## Development Facilitation Team (DFT) – Review Comments

**Project No: PR-2022-007299**    **Date: 7/3/2024**    **Agenda Item: #1**    **Zone Atlas Page: K-10**  
**Legal Description: LOTS 54 & 55 & 1, UNIT 6, TOWN OF ATRISCO GRANT**  
**Request: DFT – Site Plan Administrative for Skyview West Industrial**  
**Location: 7320 CENTRAL AVE SW between COORS and UNSER BLVD containing approximately 13.59 acre(s)**

### Application For: SI-2024-00931 – SITE PLAN DFT

**Project Name:** Site Plan Admin review for Skyview West Industrial – 7320 Central Ave SW, between Unser and Coors.

ENGINEER'S SEAL RONALD R. BOHANNAN P.E. #7868	SKYVIEW WEST ALBUQUERQUE, NM	DRAWN BY pm
	CONCEPTUAL GRADING PLAN	DATE 6-6-24
 TIERRA WEST, LLC 5571 MIDWAY PARK PL. NE ALBUQUERQUE, NEW MEXICO 87109 (505) 858-3100 www.tierrawestllc.com	SHEET # GR-1	DRAWING
6-6-24	JOB # 2023062

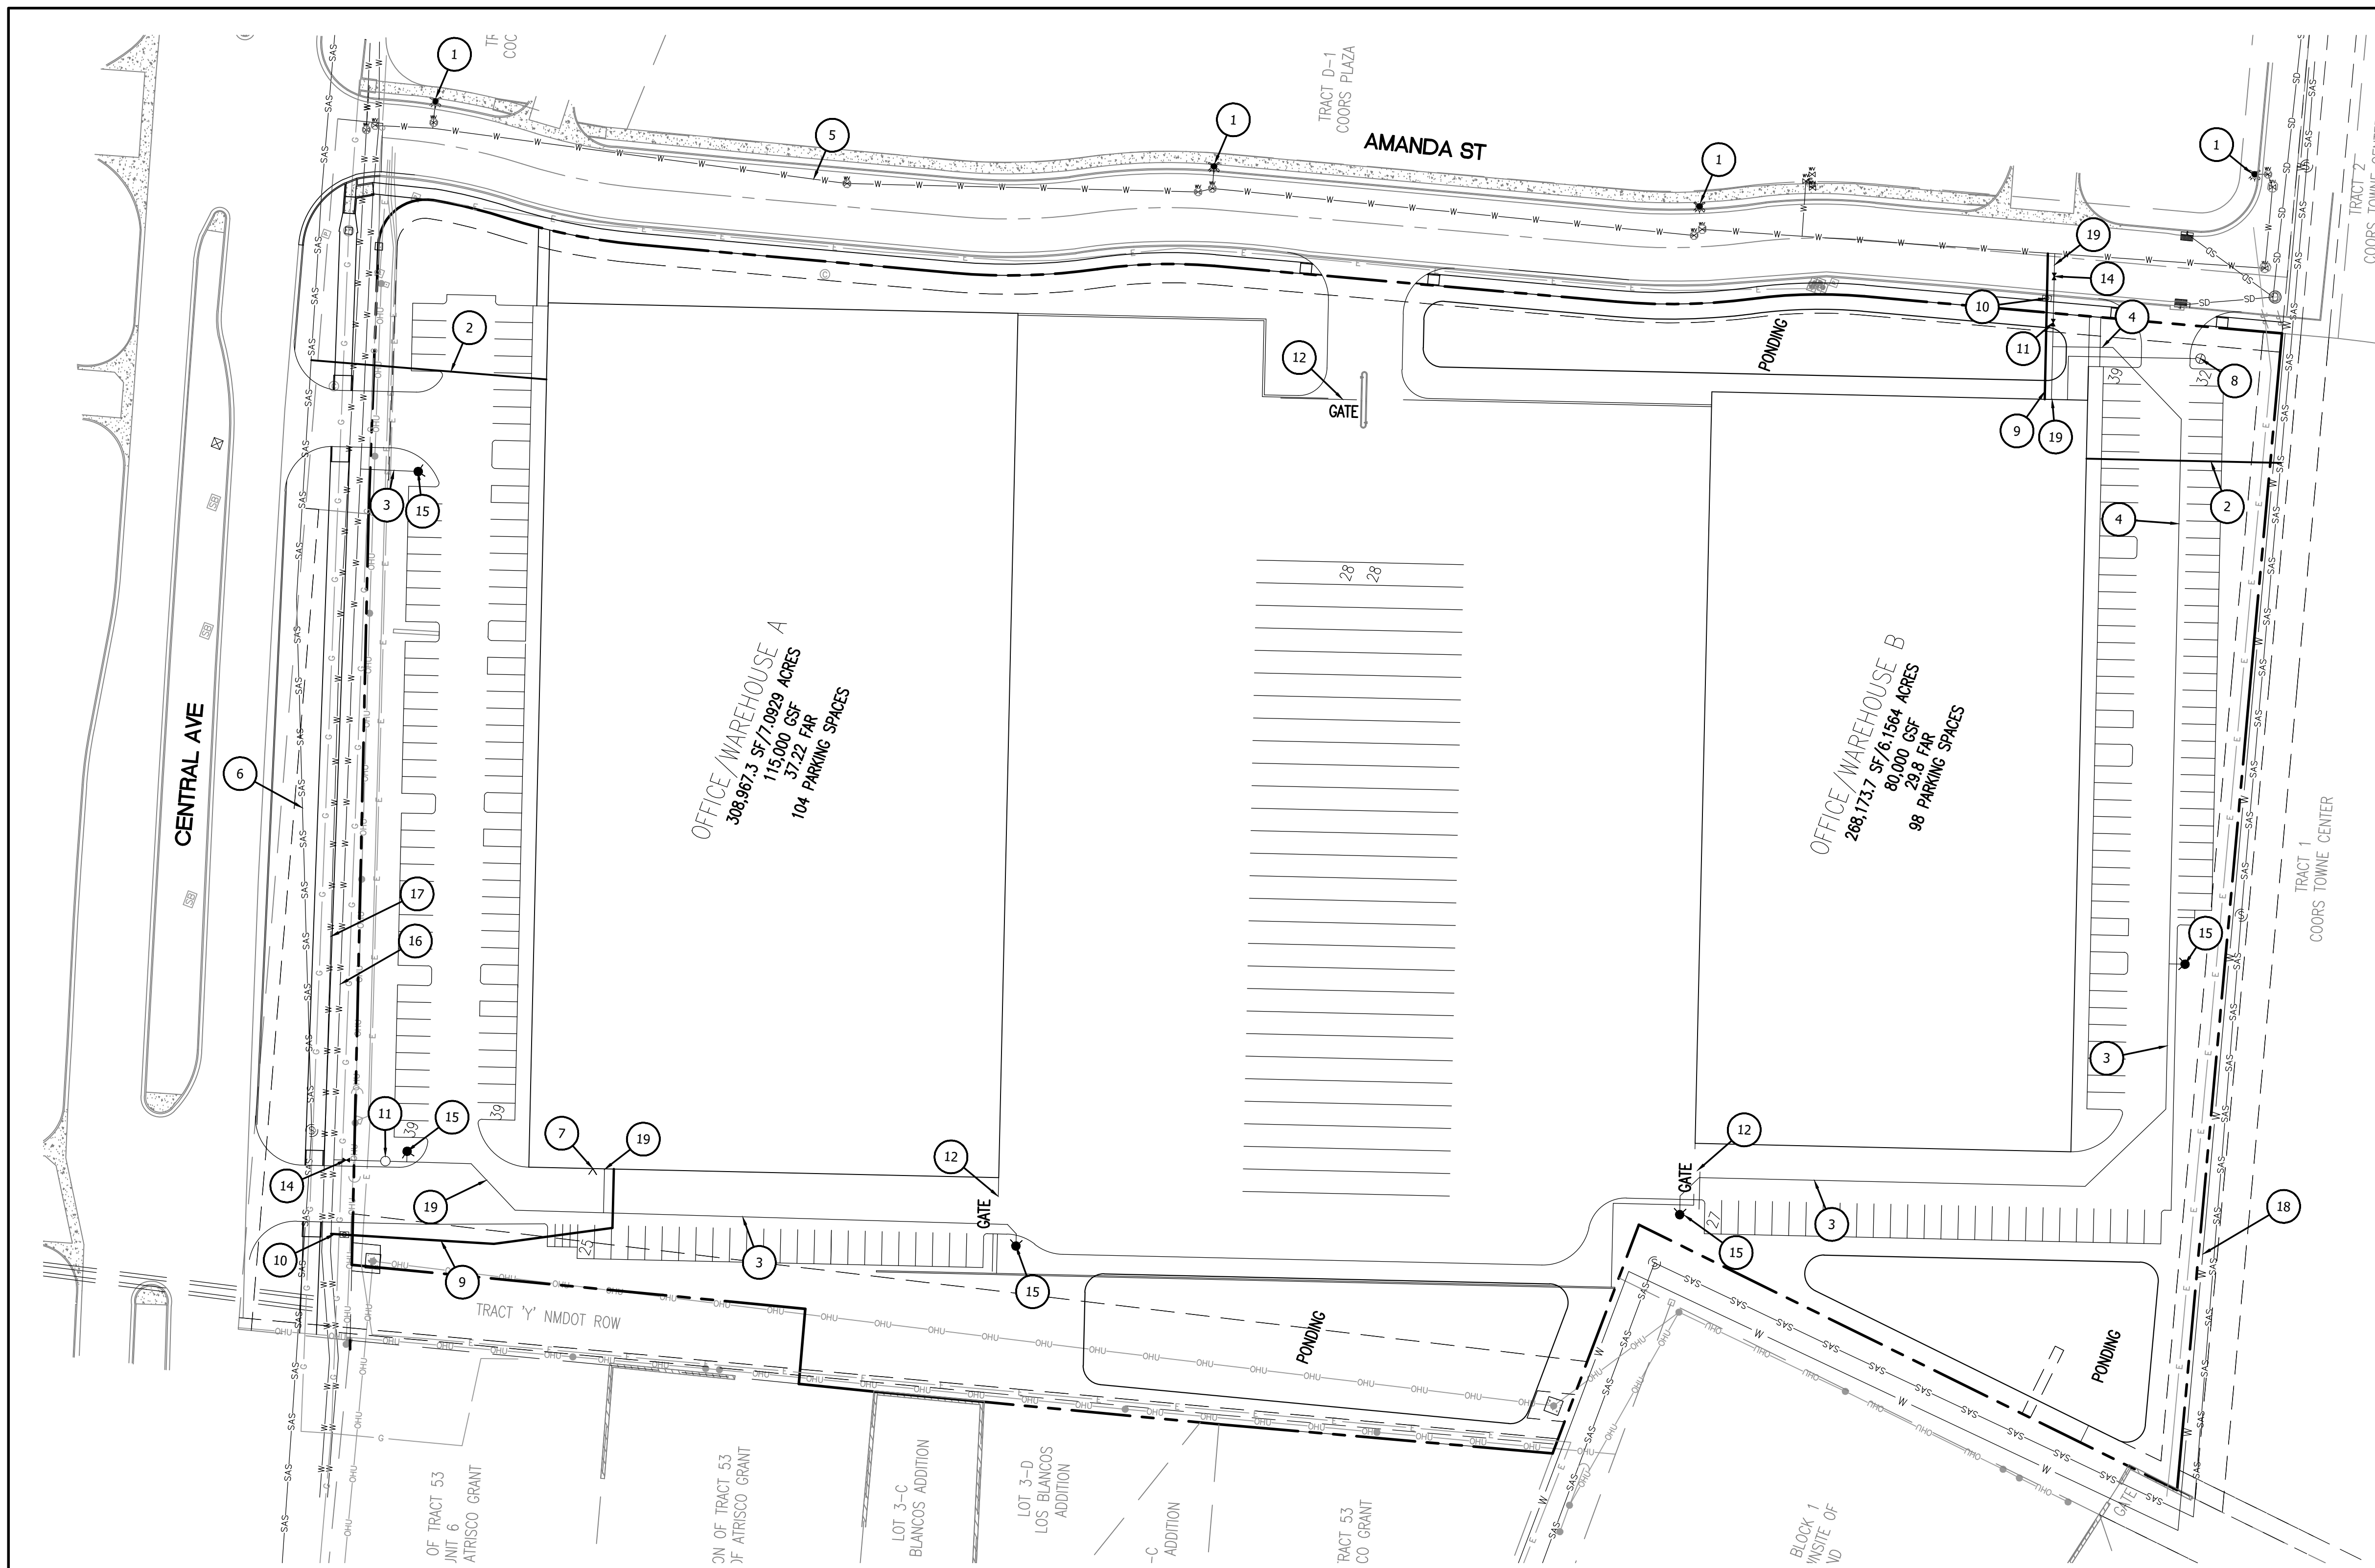
1. Please correctly label all water and sanitary sewer infrastructure.
  - a. Private vs. Public **LABELED**
  - b. Sizes are not correctly identified.
    - i. E.g. the 24” AC called out should be a 12” from my records. Please acquire record drawings and go over all of these. **CORRECTED**
